Application no: H19/1098/93

Description: Retention of dwelling without
complying with landscaping
maintenance condition
(Condition 2 of H19/0179/92)

Location: Chestnut House
239 Broadgate
Sutton St Edmund
Spalding

Type: SEC 73 MODIFICATION

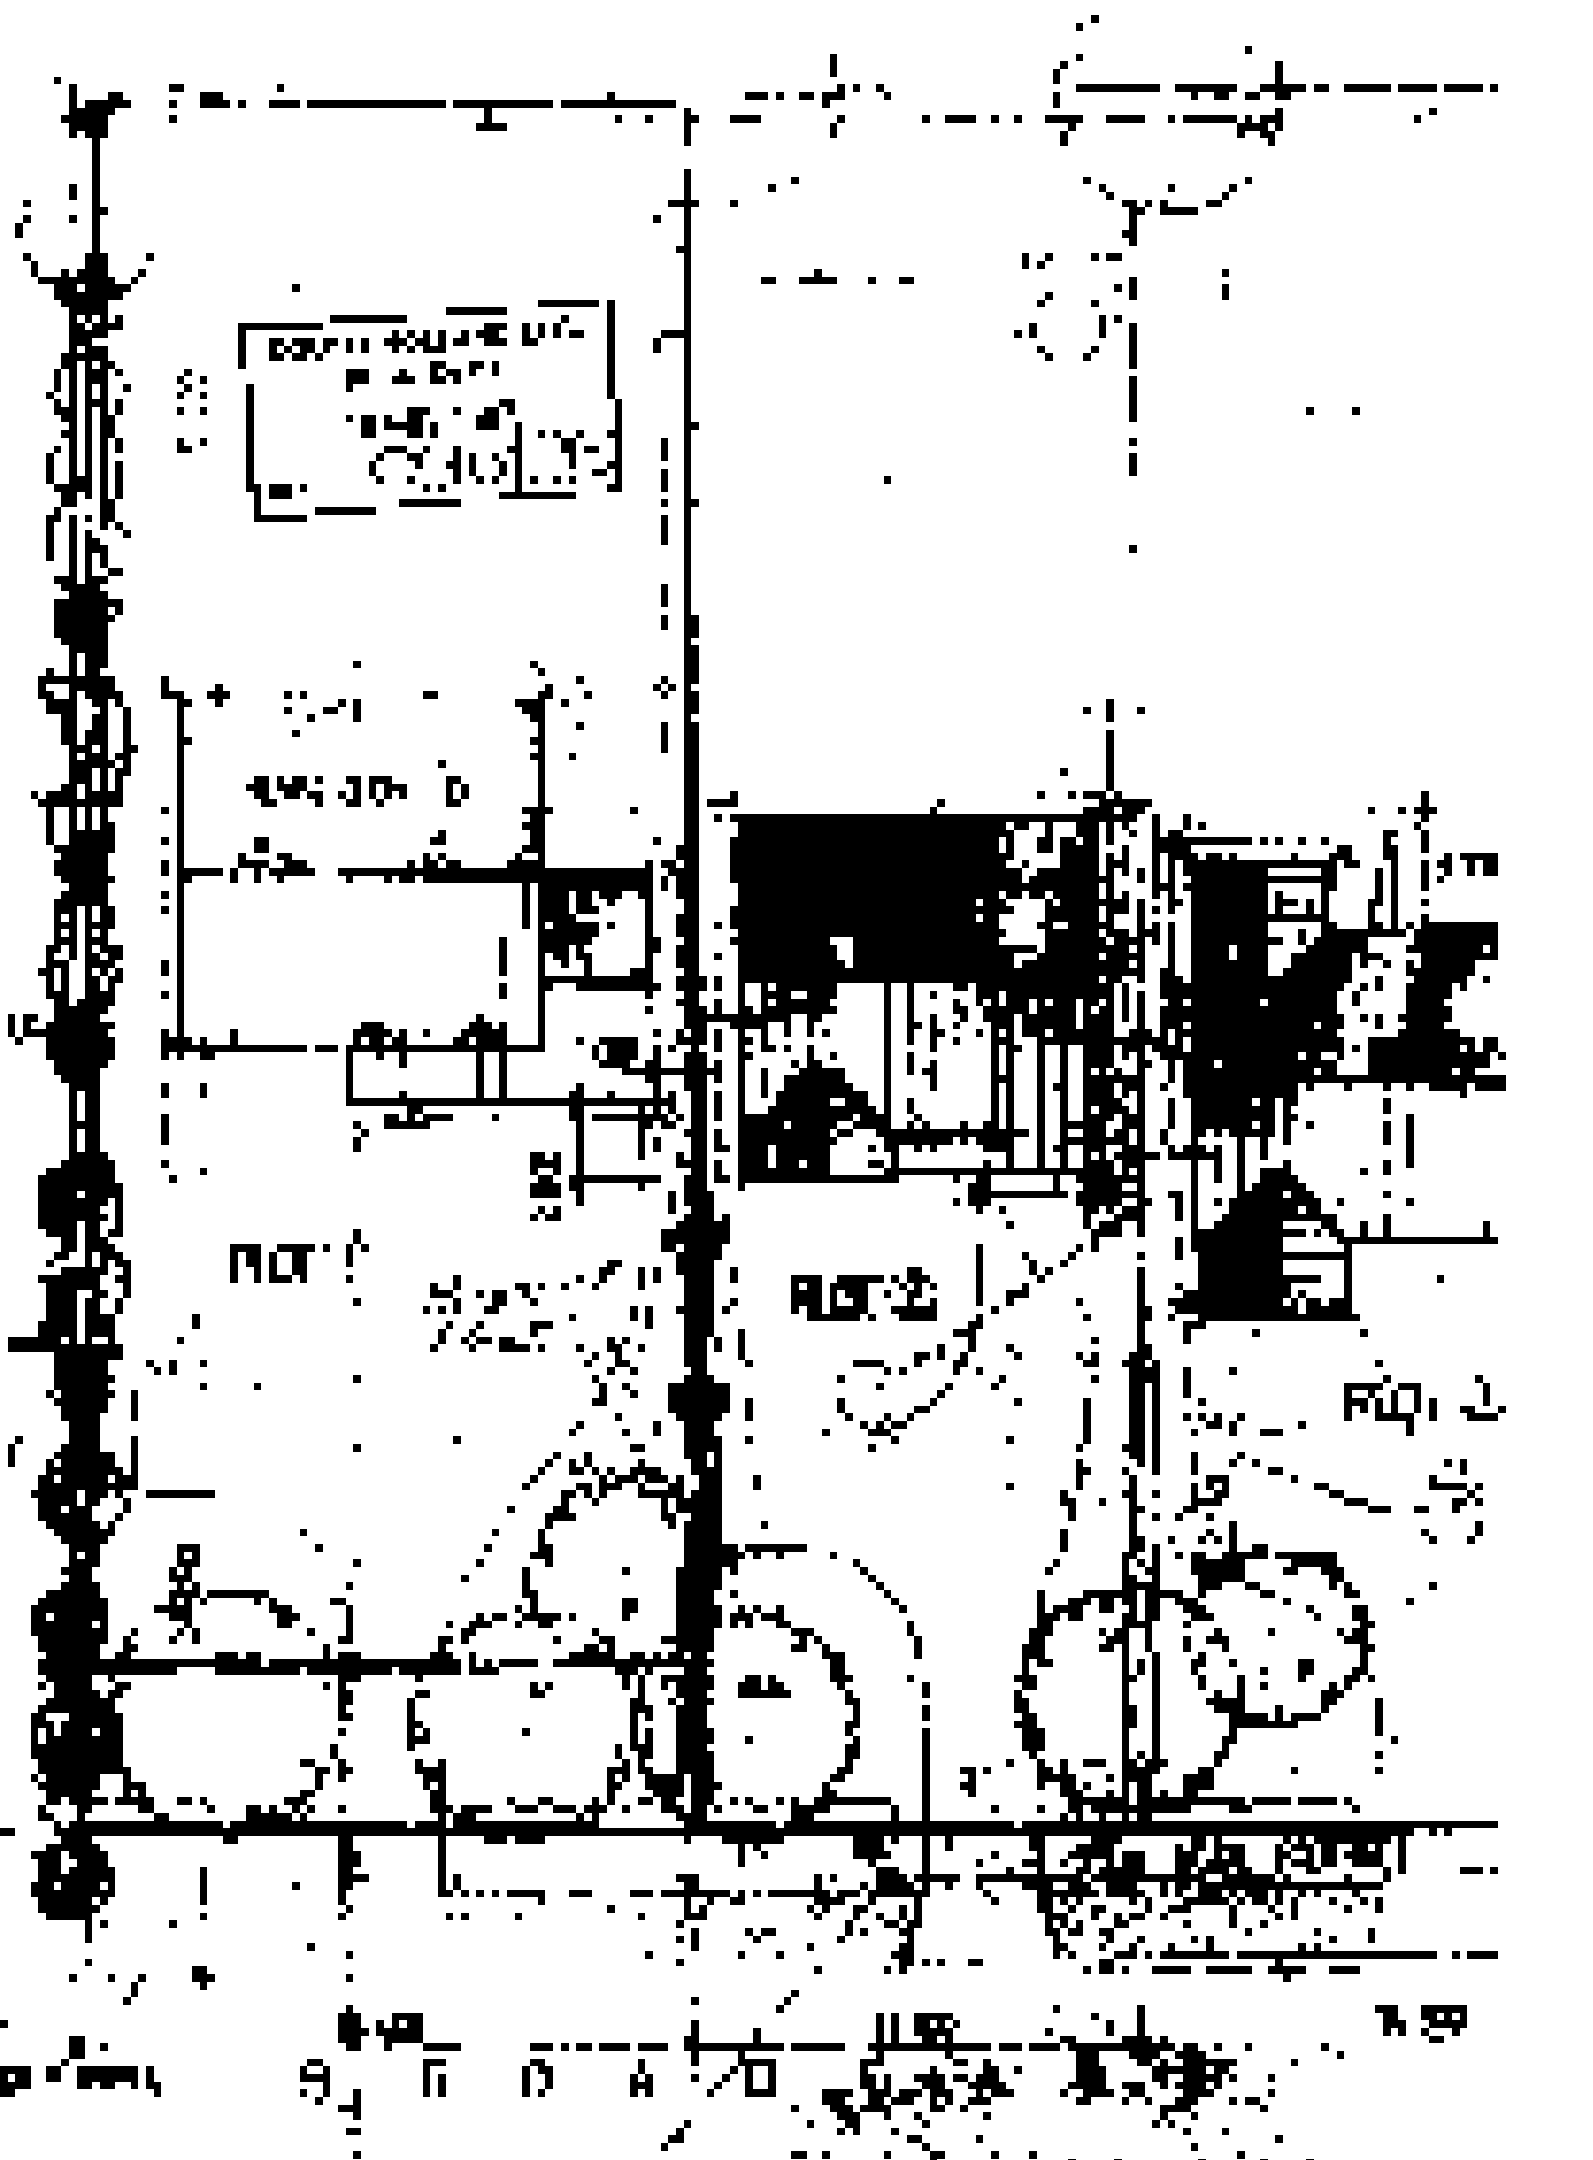
- 1 In the opinion of the Local Planning Authority the ~~retention of the dwelling without complying with the landscaping maintenance condition~~ would result in an unsatisfactory landscaping ~~scheme~~ ^{which} upon the site which would not ^{harmonise with} ~~complement~~ the rural nature of the village of Sutton St Edmunds. Consequently, the new development would appear more "urban" in nature and, ~~therefore~~, out of character with the rural locality. The proposal would, therefore, be harmful to the purpose of Structure Plan Policy 5A and also advice contained within Planning Policy Guidance Note 3, 1992 (Housing), because as well as its individual effect, ~~the~~ ^{the proposal} ~~it~~ would encourage further similar proposals which would then be hard to resist.

- 1 These applications have been submitted since the owners of Plots 1 and 3 have, ~~inter alia~~, replaced approved ~~indigenous~~ hedging with evergreen and privet. The owners of Plot 4 (and also possibly Plot 2) have also modified the approved scheme.
- 2 The original landscaping has mainly been substituted ~~by~~ ^{WITH} species which are less "rural" in nature; This is ~~considered~~ unacceptable, and if the proposals were to be permitted it would encourage either the total removal of ~~indigenous landscaping~~ or its substitution ^{SPECIES} by species which are less appropriate to the rural locality.
- 3 It should be noted that the majority of the trees and also the hedging at the rear have not yet been planted. However, the applicants are not in breach of Condition 2 ^{IN THIS RESPECT} until 13 May 1994 (two years from the date development commenced).

With reference to the above application, I assume
the conditions as imposed on the original approval
were to protect the local environment and
ensure that planting and species would be
sympathetic with the local rural area. I see
no reason for a change of policy or view from
these original conditions. In fact in my
opinion a reversal of this condition must put
into question the reason for imposing it in
the first place.

instead of 6 months, 12 months to implement the approved landscaping scheme, full (including the trees and hedging at the rear) by the 13 May 1994.
